RFI

**RFI #: 41**  
**Date:** 1/28/2012  
**Job:** EB-02 Keller Springs Lofts  
**Phone:** 877-777-5115

**Subject:** Elevation conflict A1 part 1 Division F

**RFI #: 90**  
**Date:** 3/27/2012  
**Job:** EB-02 Keller Springs Lofts  
**Phone:** 877-777-5115

5 UNIT A1 - PARTIAL 2
SCALE: 1/4" = 1'-0" OCCURS AT: (5) TOTAL UNITS ON SITE

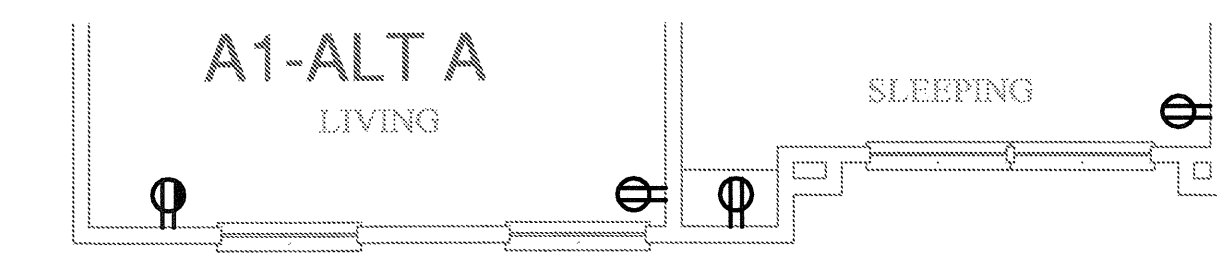
**Request:** Date Required: 2/2/2012  
 8/2.2 shows the A1 partial 1 as having an H mark window in bedroom. 3.1F shows the A1 part units with a 3' window H= 3'. 1/4.1 shows same A1 part. unit with a 4' window. Please give direction.

**Response:**  
 All plans are accurate. The elevations have been updated.  
 See next pages for more info.
